Current Zoning: N1-A (neighborhood 1-A)
Proposed Zoning: N1-F(CD) (neighborhood 1-F, conditional)

Approximately 0.997 acres located along the west side of Park South Drive, east of Parkstone Drive, and north of Archdale Drive.

The petition proposes to develop two triplex buildings and one quadplex on two parcels currently developed with two single family detached homes.

PLANNING STAFF REVIEW

**RZ-1**

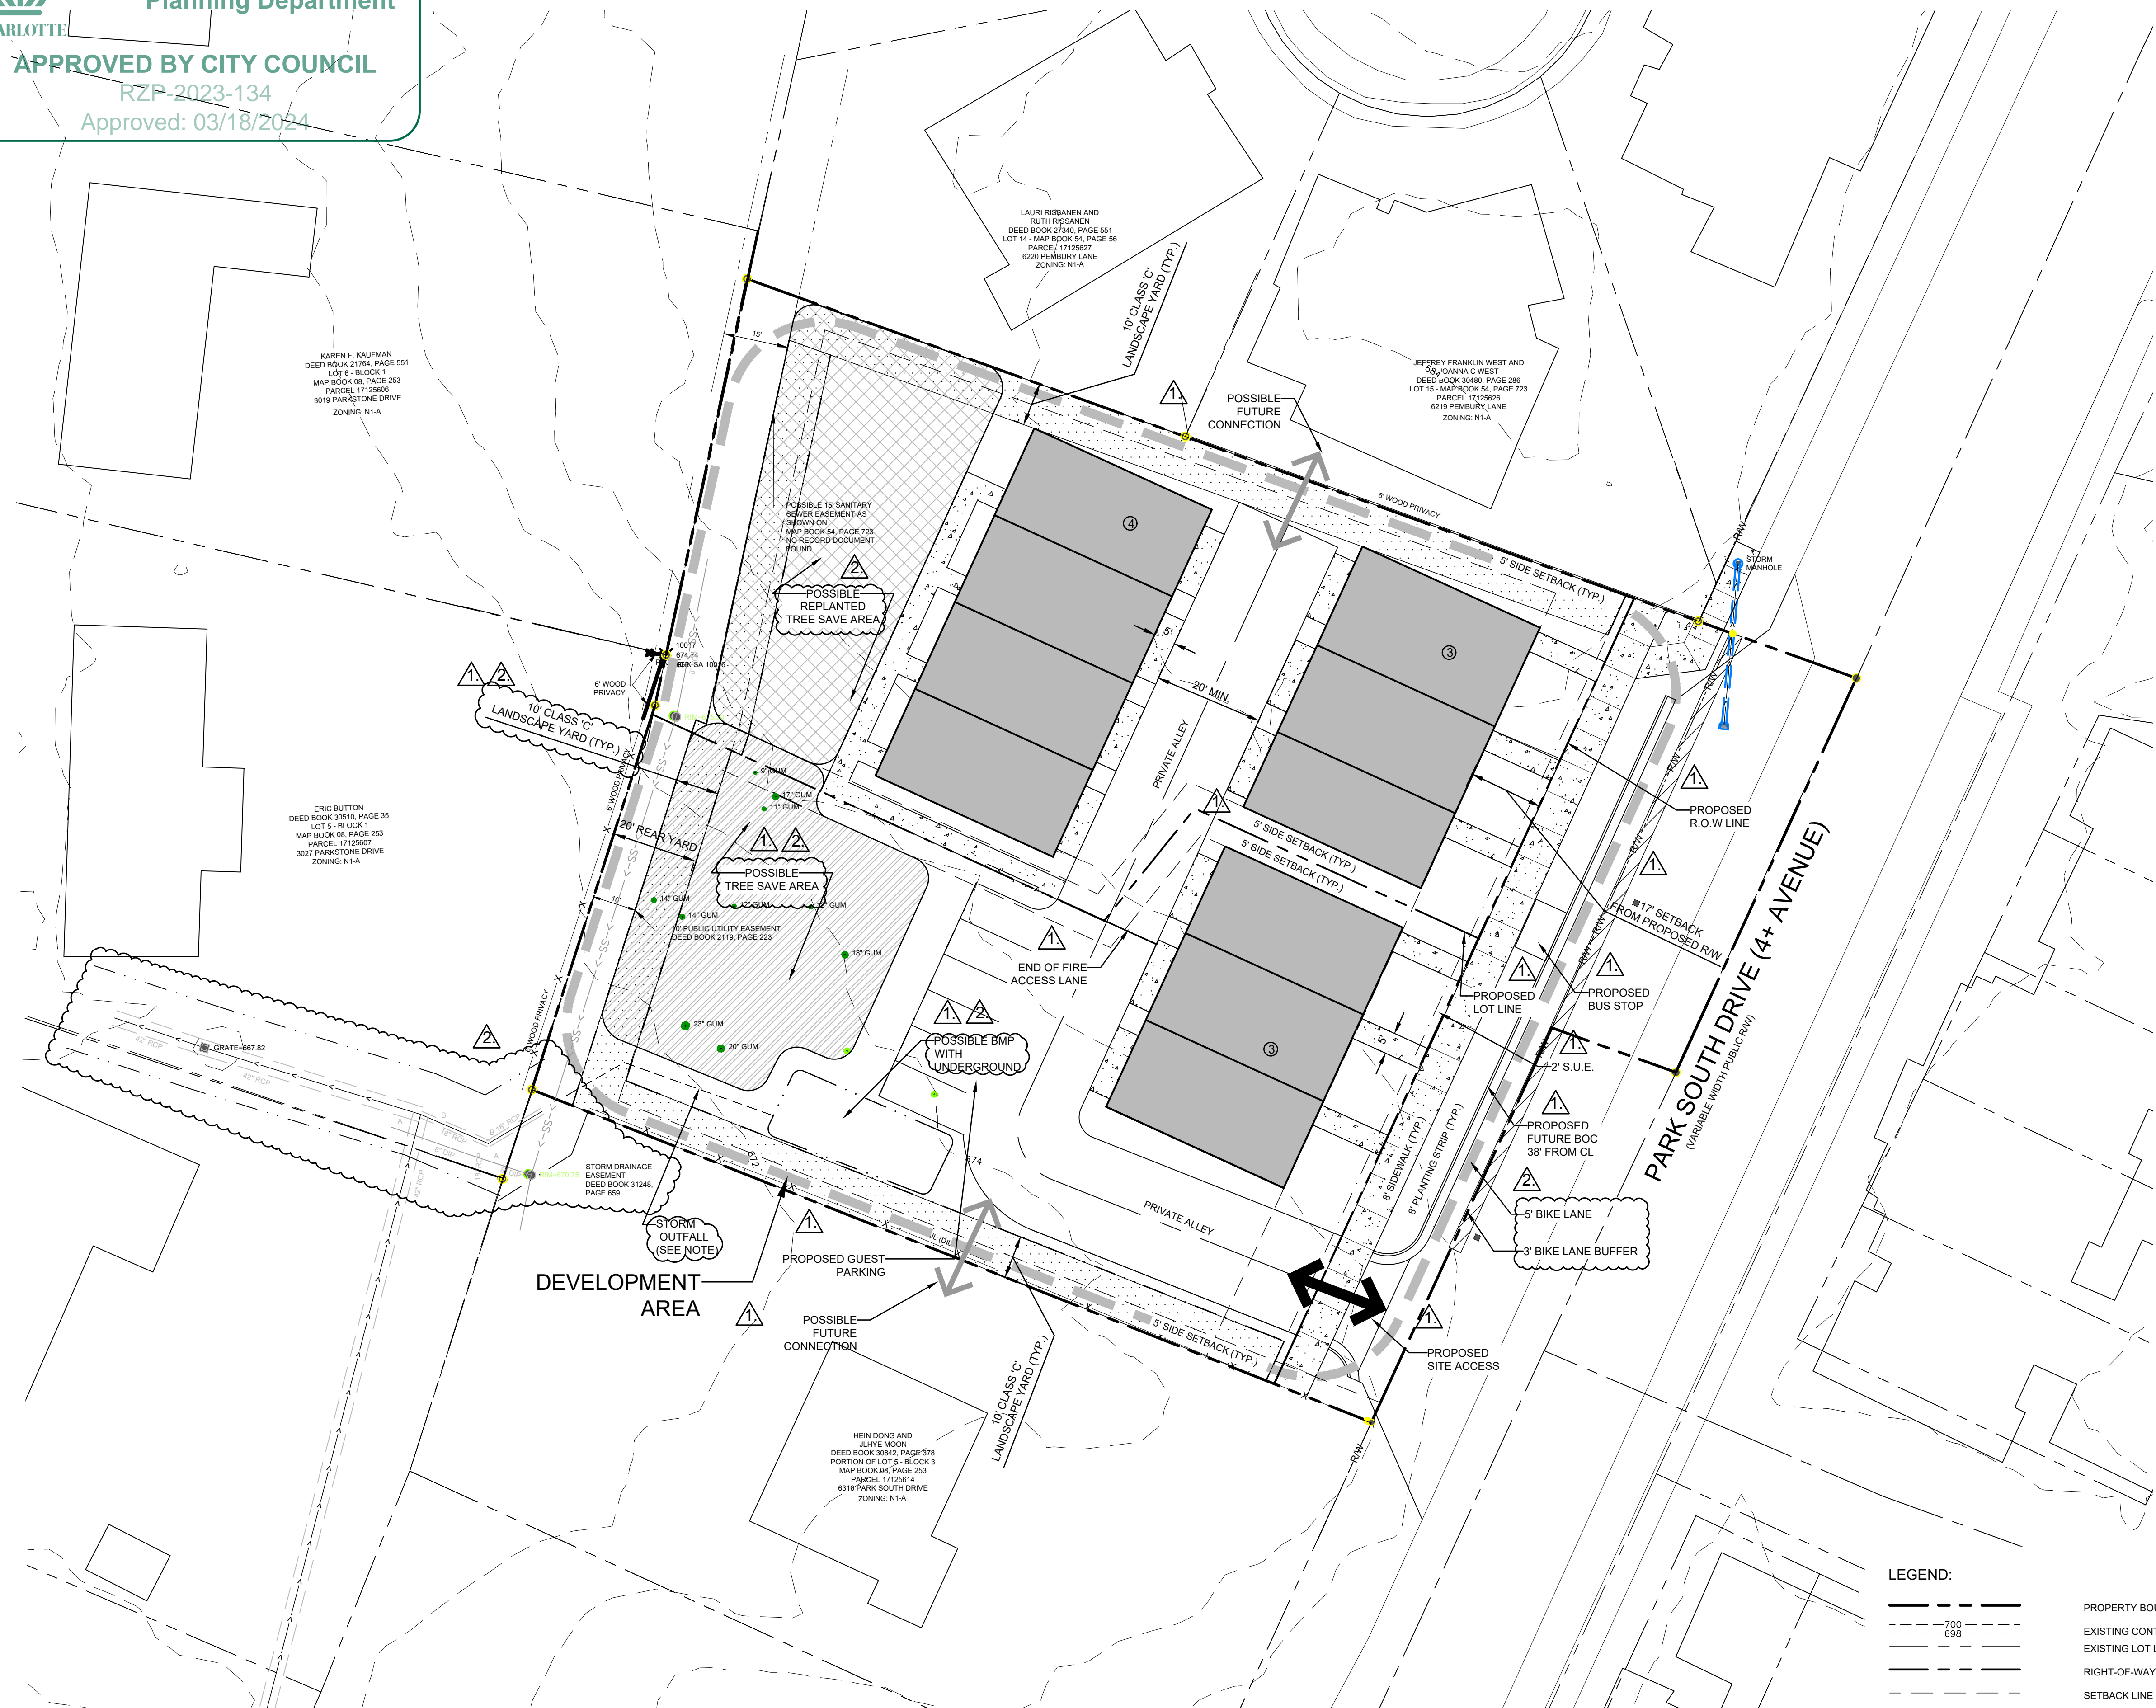
1. ~~Revise the proposed driveways for the individual units to be compliant with Article 19.6.A.1.a of the UDO.~~ **Addressed**

2. ~~Clarify if the tree save area shown on the site plan is outside of the demolition plan.~~ **Addressed**
3. ~~The replanted tree save area will have to be at a higher rate than the required minimum of 15% of the site. Increase the proposed tree save on the plan.~~ **Addressed**

4. ~~The dimension for the proposed back of curb to the center line must be shown on the site plan as well as the buffered bike lane that is required per the Charlotte Streets Map cross section.~~ **Addressed**

5. ~~Revise conditional notes from note K in the transportation provisions to remove the wording, "as generally depicted on the site plan," since this commitment is not depicted on the site plan.~~ **Addressed**
